Penrith Glass Beneficiation Project SSD-5267 – EPA Comment and Recommended Conditions of Consent

The EPA has reviewed the Benbow Environmental "*Environmental Impact Statement for Glass Recovery Services 126 Andrews Rd, Penrith*" May 2013 (the EIS) and provides comments as outlined in Attachment 1.

SSD 5267 EPA Comments

126 ANDREWS ROAD PENRITH
WETLAND & CONCRETE HARDSTAND DESIGN

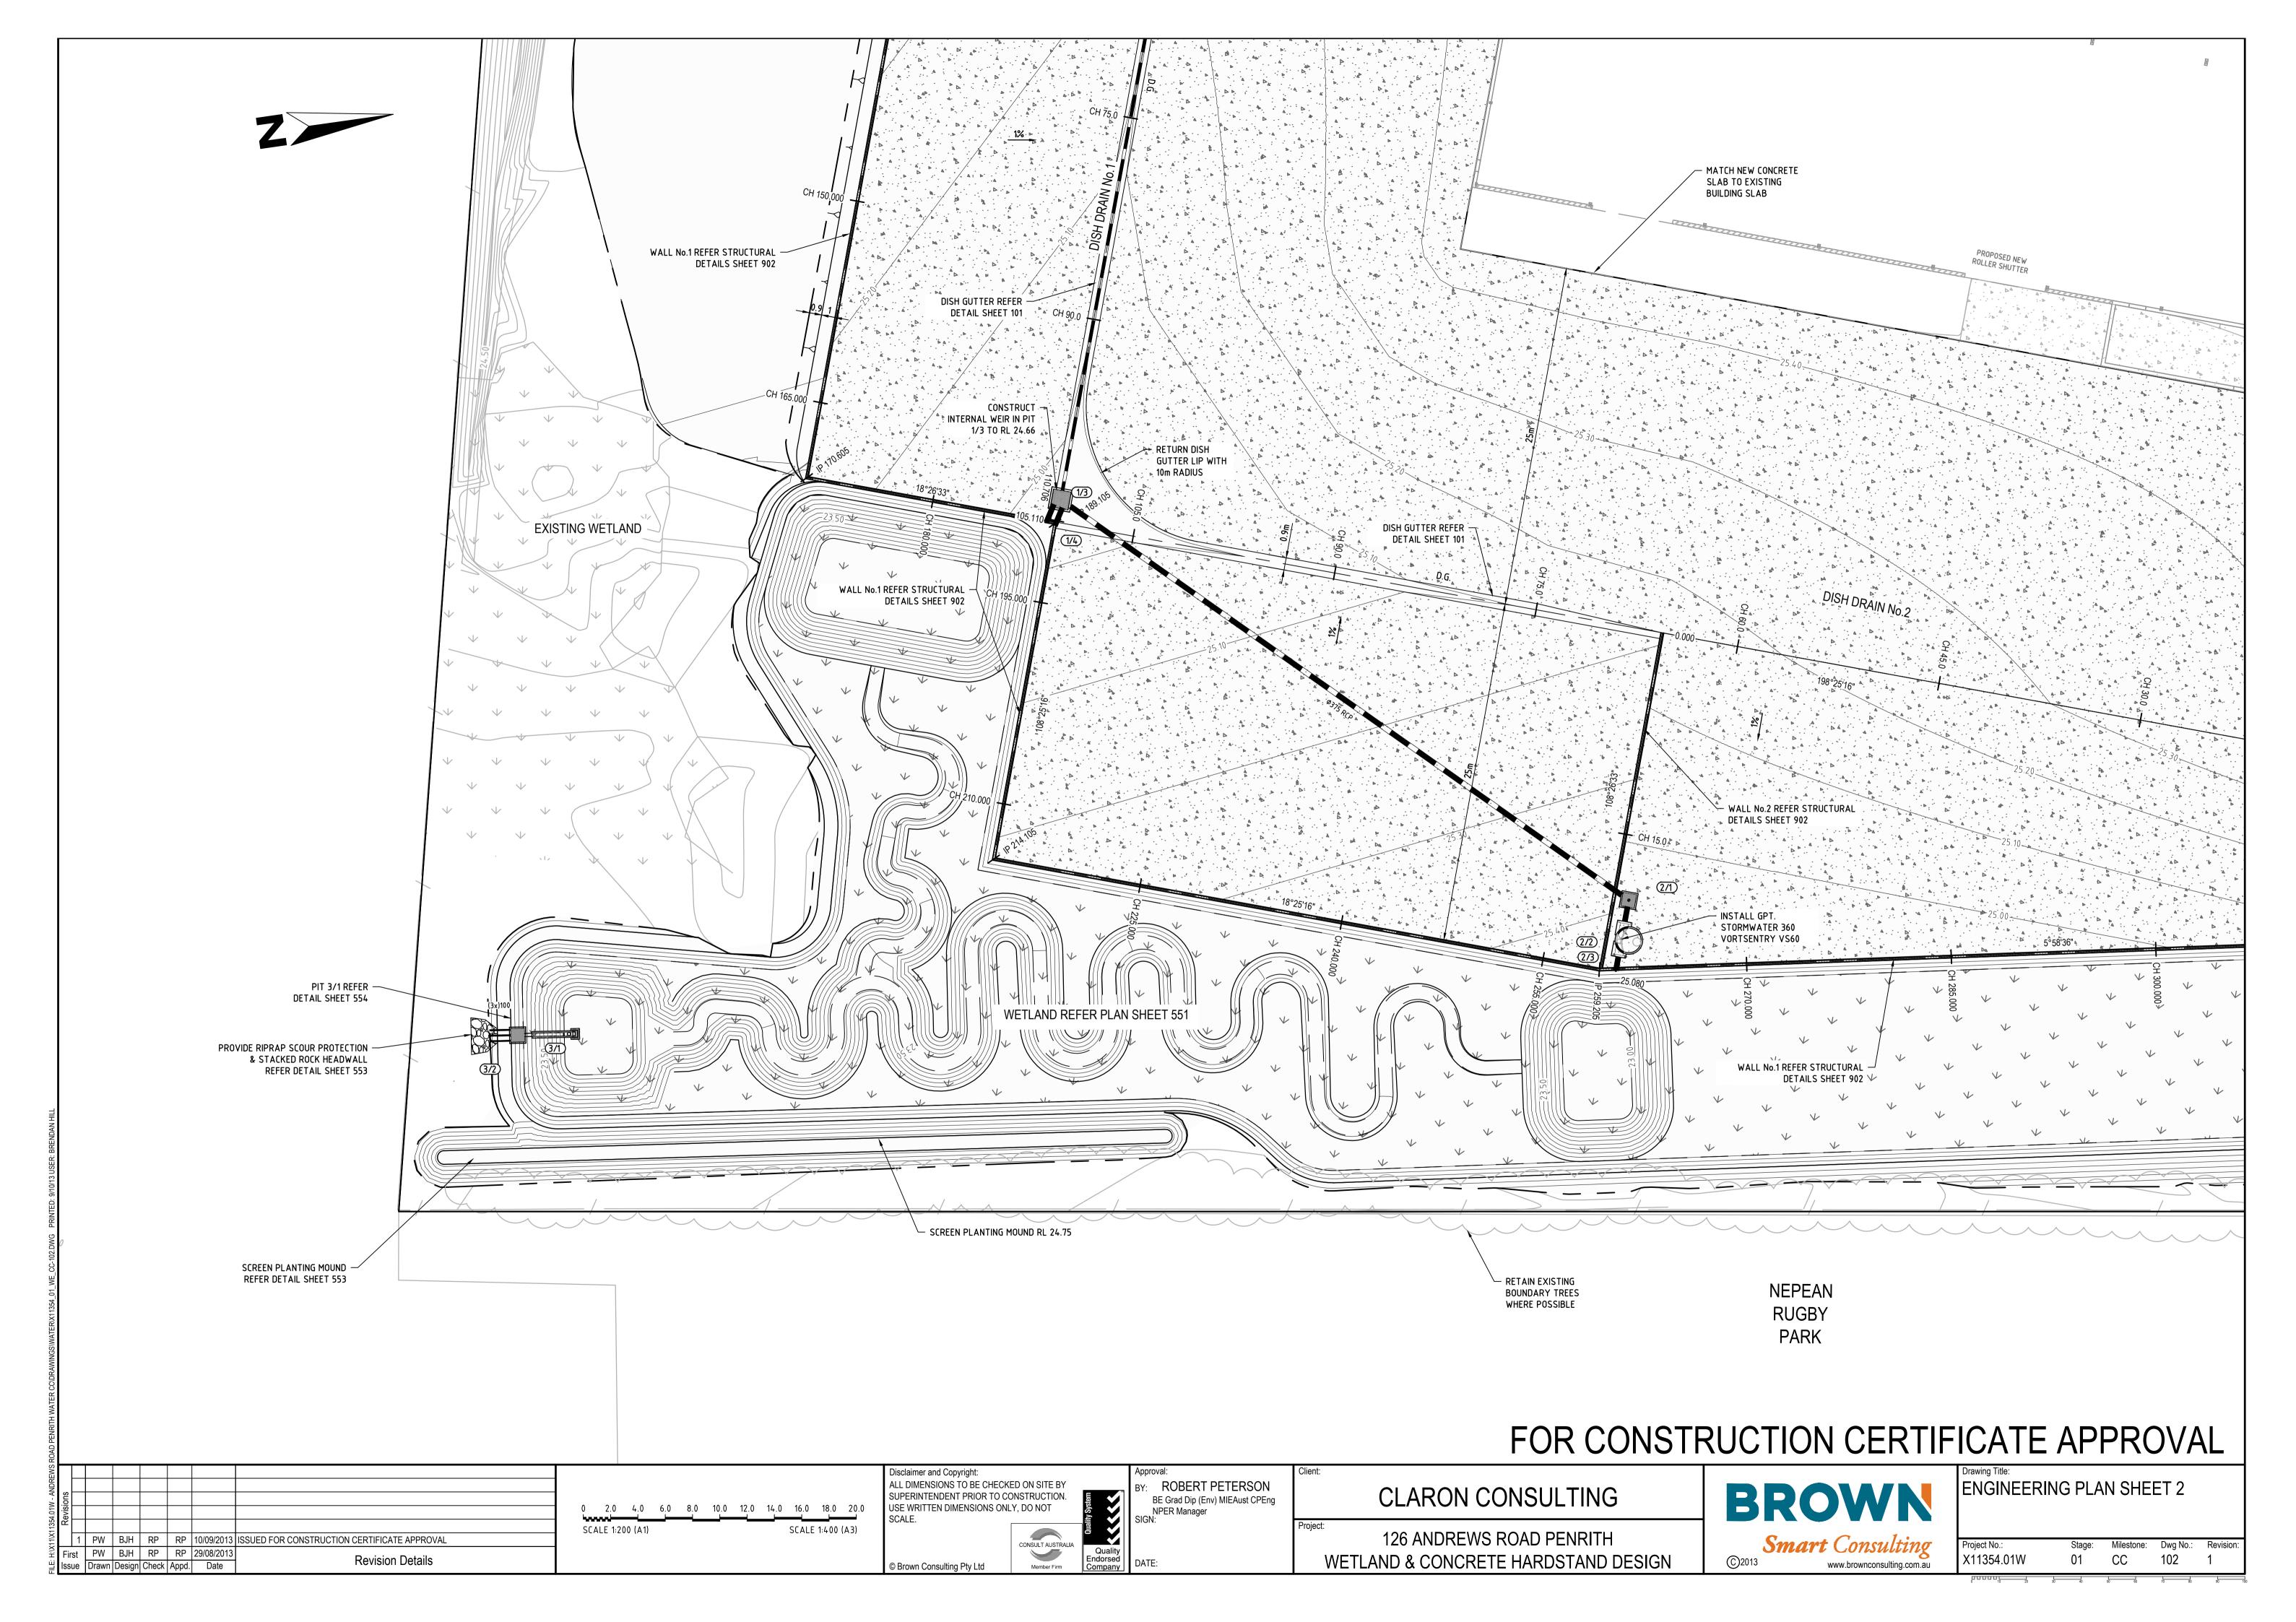
The external storage bays are proposed to be constructed within a floodplain. To maintain flood storage volume the proposal has designed 1 in 100 floodwaters to surcharge back in to these external bunkers.

During the review of the draft EIS, the EPA expressed concerns that glass cullet could potentially be carried out of the storage bays during flooding. The applicant subsequently provided the EPA with correspondence

entitled *Brown Smart Consulting X11354 EPA letter Rev01 17 May, 2013* that committed to the installation of floodwater containment bunds around the storage bay area, in order to ensure that all water would discharge from this area via the CDS interceptors. This correspondence was provided as a revision of the *Brown Smart Consulting X11354.W* referred to in the EIS.

Recommendation: The EPA requests the assessment be updated to include the advice of 17 May 2013. The EPA will require the installation and maintenance of floodwater containment bunds around the storage bay areas to ensure that all water, including floodwaters would discharge via the CDS interceptors.
